# Rezoning Transportation Analysis

Petition Number: #2021-256

Date	Description
04-12-2022	First Review (AO)
08-22-2022	Second Review (AO)
01-25-2023	Third Review (TM)
03-22-2023	Fourth Review (DR)
04-20-23	Fifth Review (TM)

Drawing Title:
TECHNICAL PLAN SHEET
RZ-1

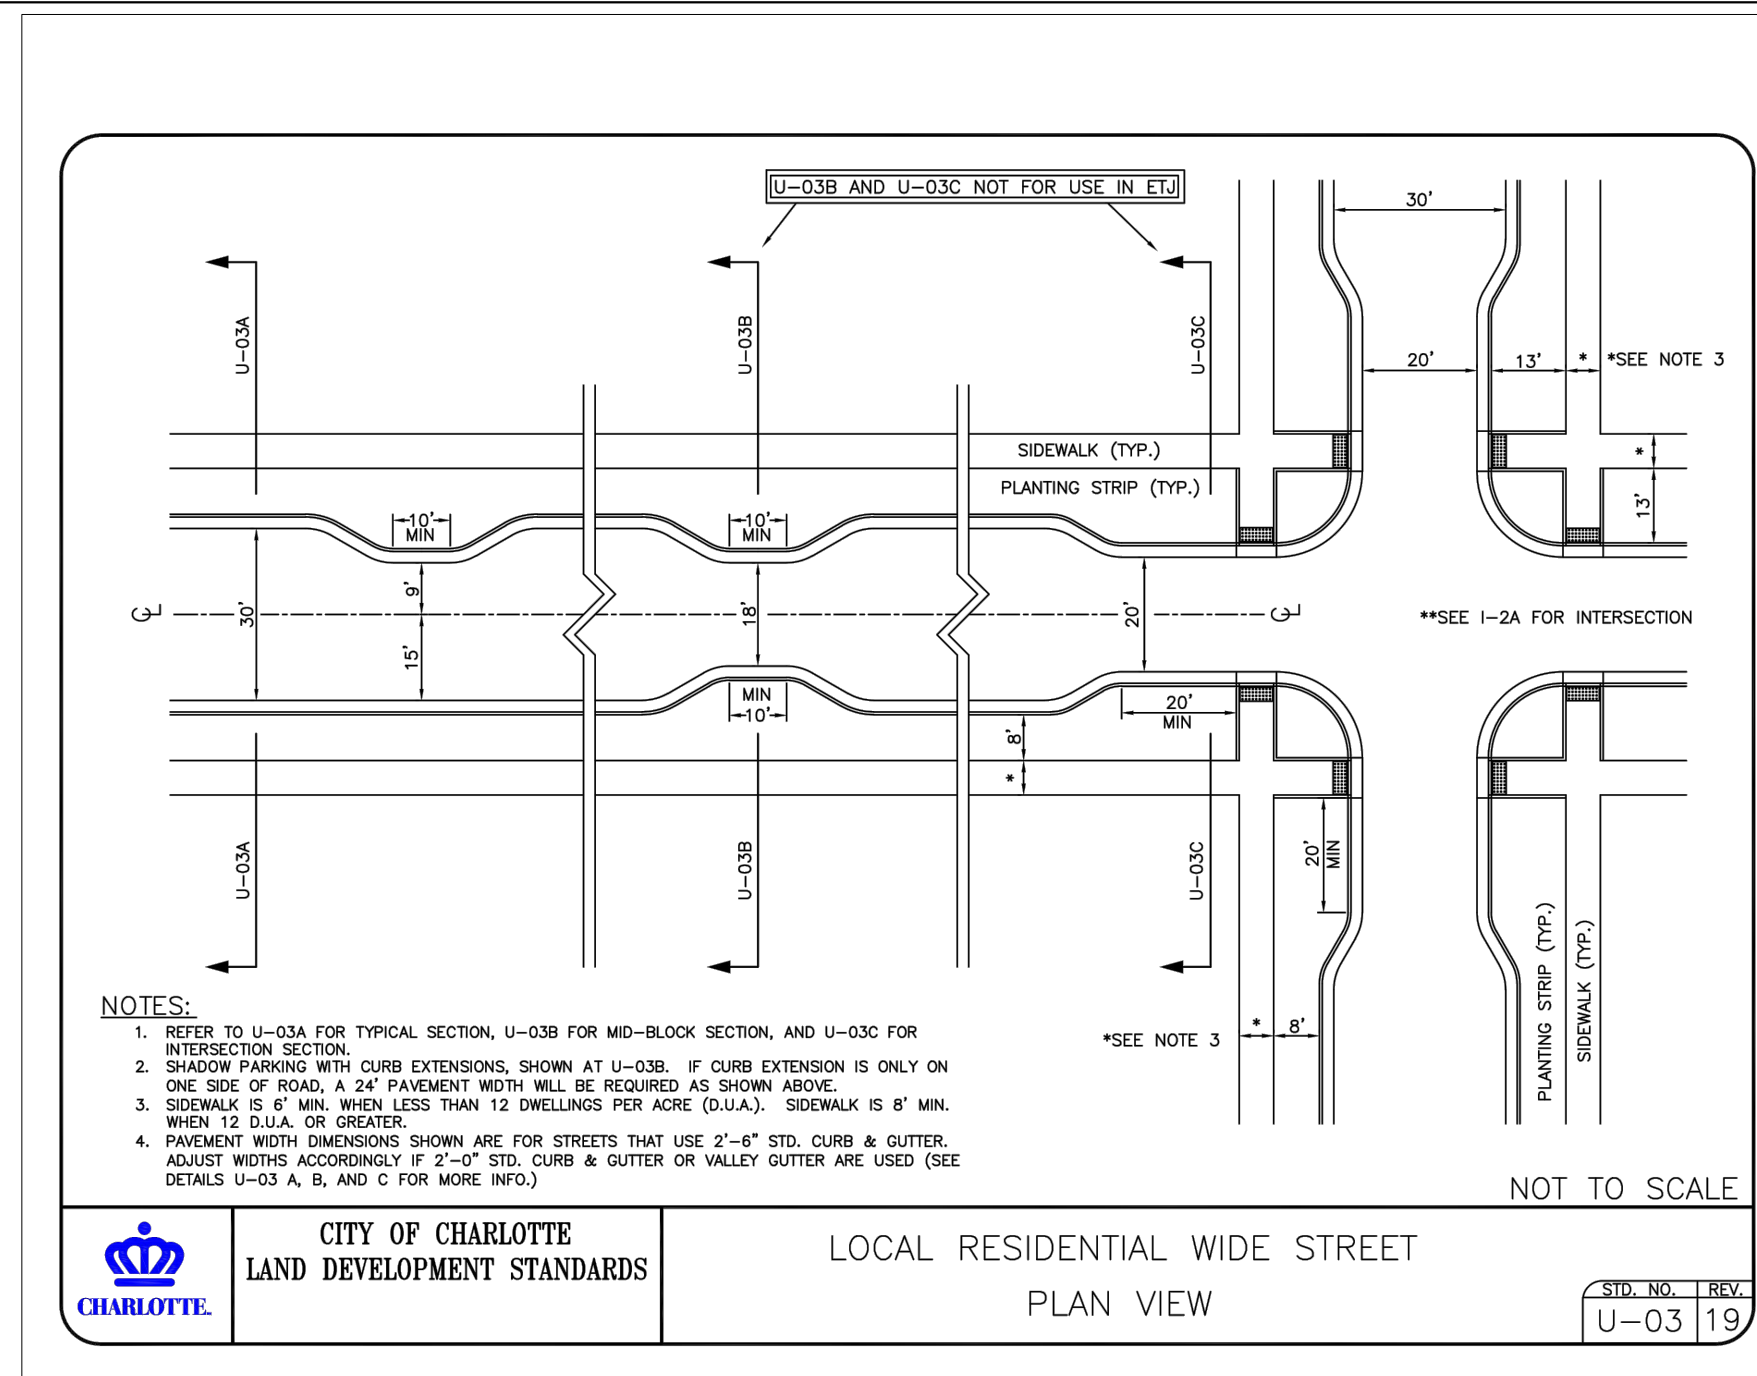
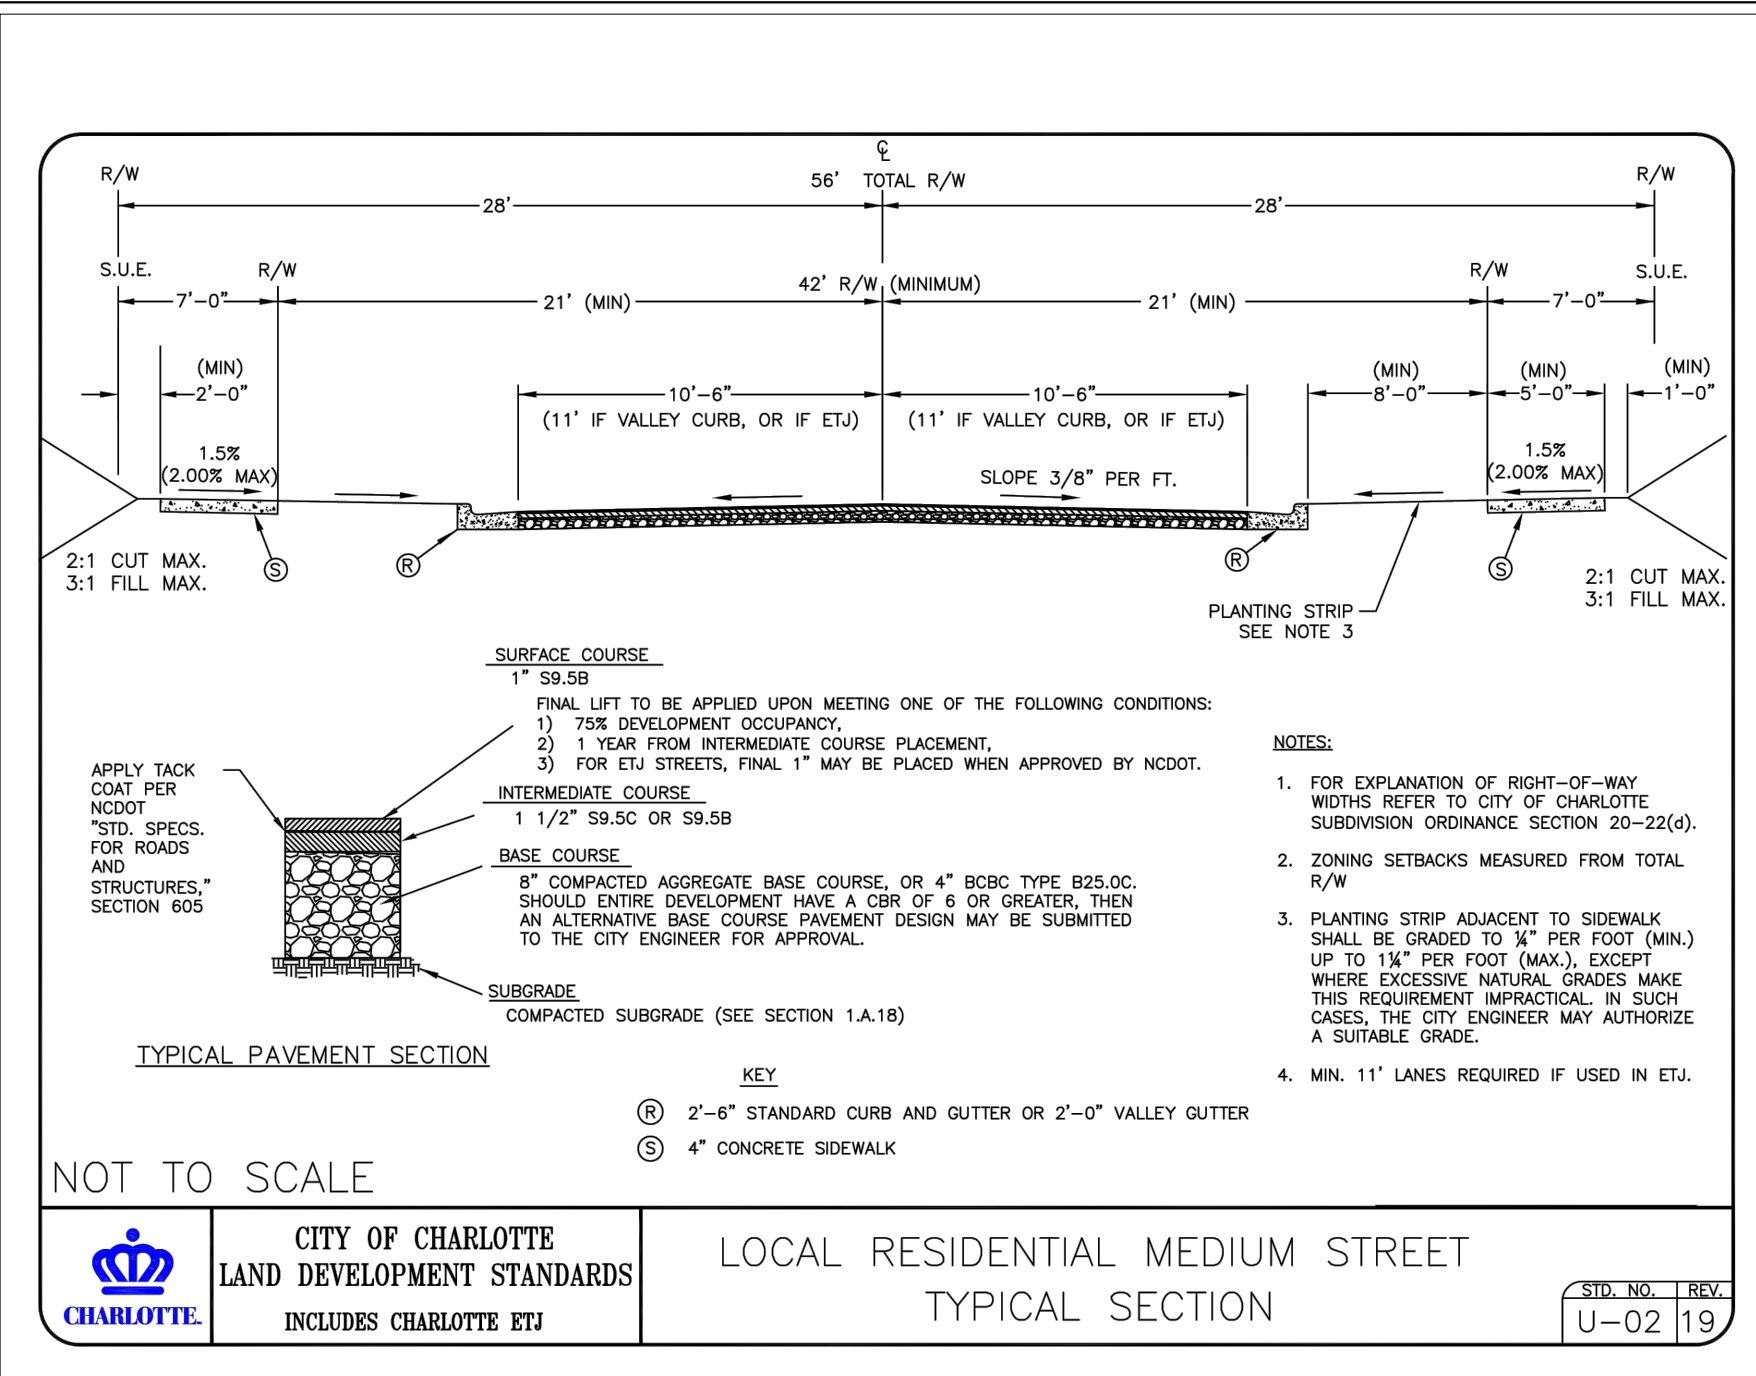
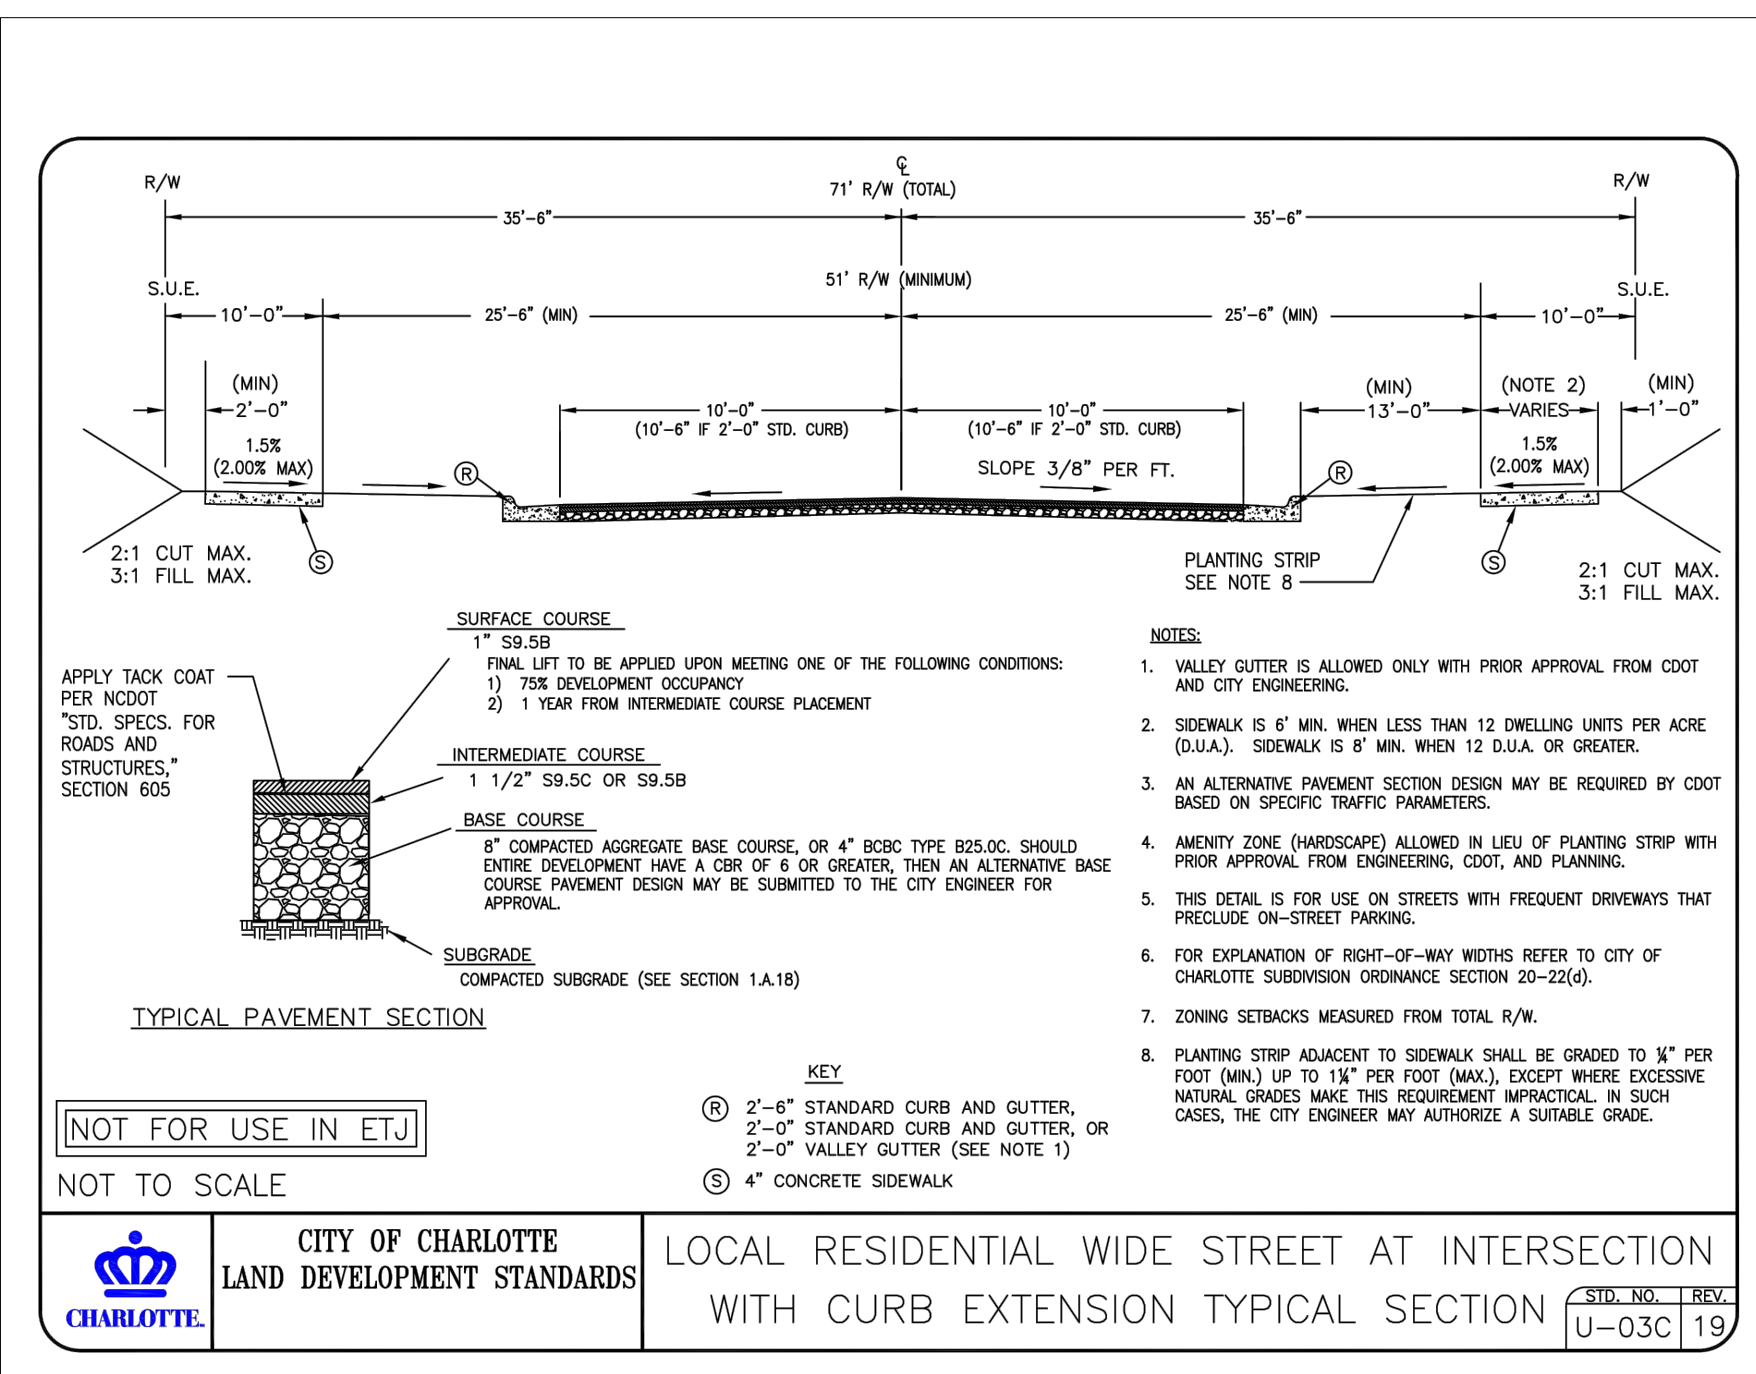
3. **New Comment 4-20-23:** Update conditional transportation notes to include the TIS improvement of installing flashing yellow arrow signal heads for all left turn movements at the intersection of Old Concord Road and Orr Road.

4. **New Comment 4-20-23:** Remove note 9 stating petitioner shall not be required to construct off-site improvements.

9. In the event that there is not existing right of way for any required off-site transportation improvement, Petitioner shall not be required to construct such off-site transportation improvement. However, in such event, Petitioner shall pay to CDOT an amount equal to the cost to install (exclusive of the cost of the right of way) the relevant off-site transportation improvement in lieu of constructing the same.
